Application for Approval of Details Reserved by Condition

Land to the rear of St Luke's, Bierley Marsh

Land to the rear of St Luke's, Bierley Marsh
The development proposed is 5 dwellings in two blocks – one 4 terraced houses, one single bungalow type hous

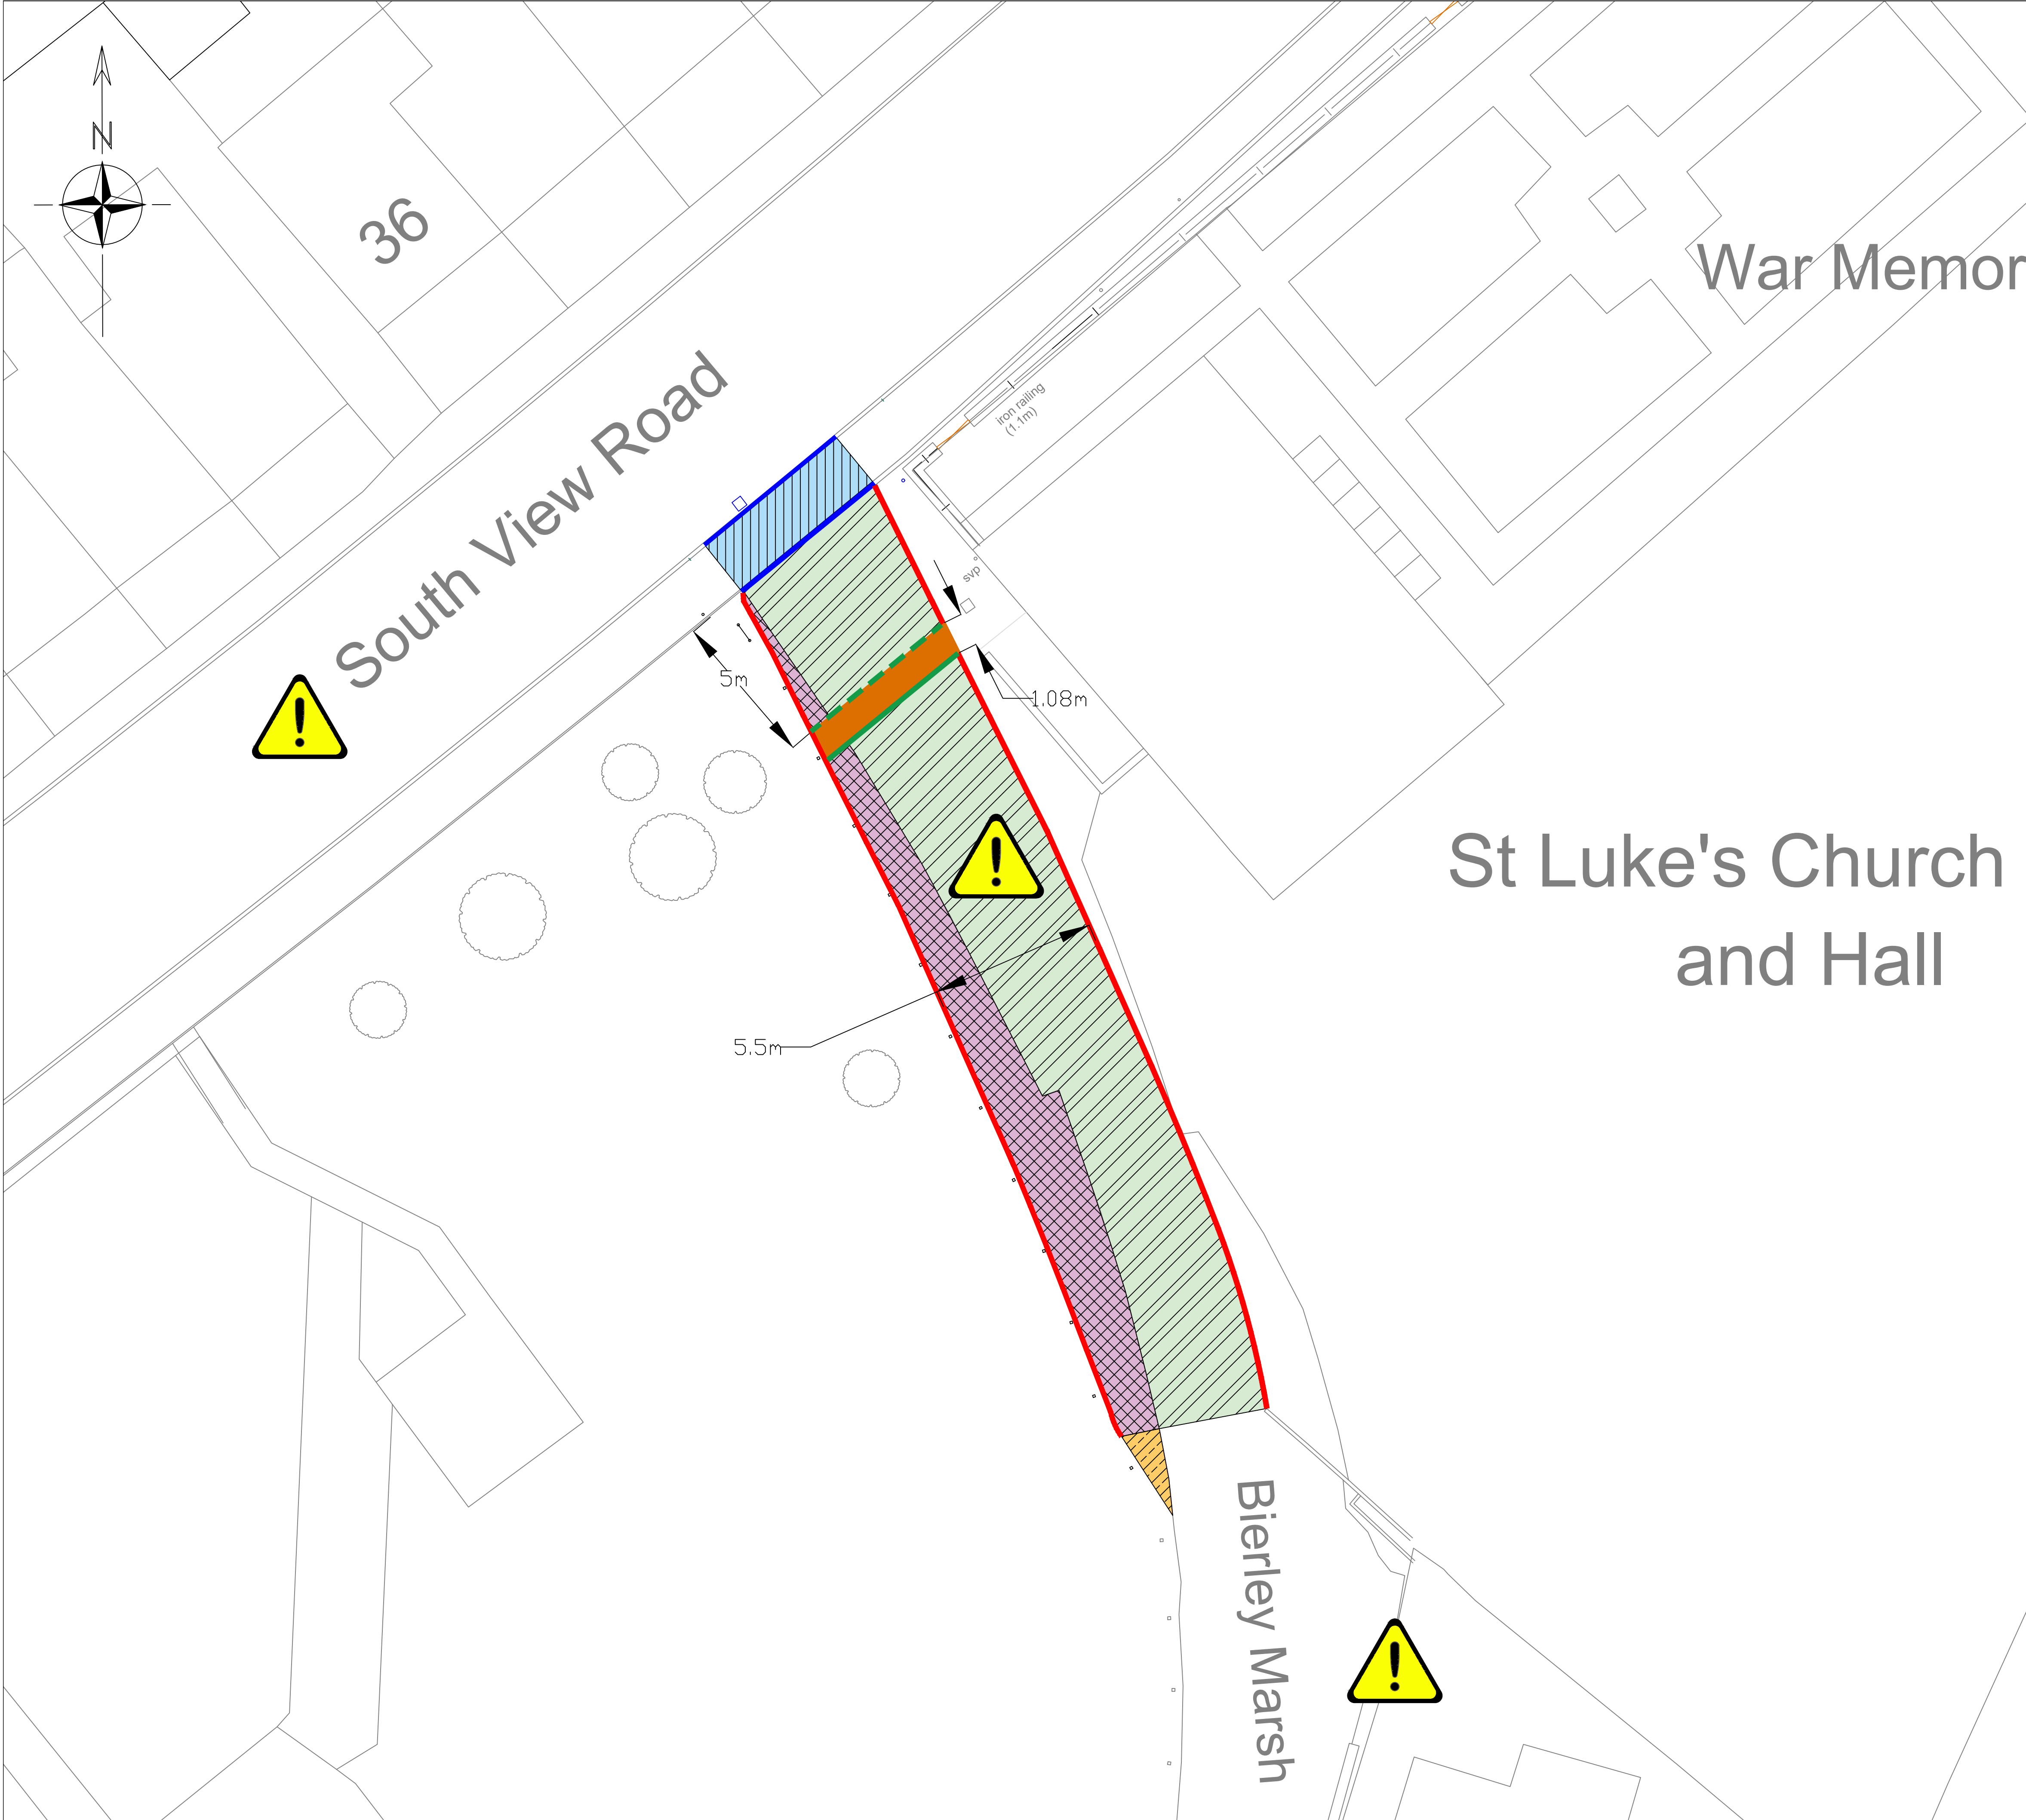
The following amendments and additions were requested by Kirklees Highways to be included within the proposal.
The omission of the traffic calming ramp shown at the entrance on approved plan number 19-157.104B.
The omission of the surfacing to the front of the church shown within the red line boundary of plan number 19-157-101 referred to in condition 5.
The provision of concrete edgings (or otherwise agreed edgings) as demarcation of the width proposed Bierley Marsh carriageway (minimum width 5.5m). Alignment to be agreed.
Details of the surfacing of Bierley Marsh carriageway.
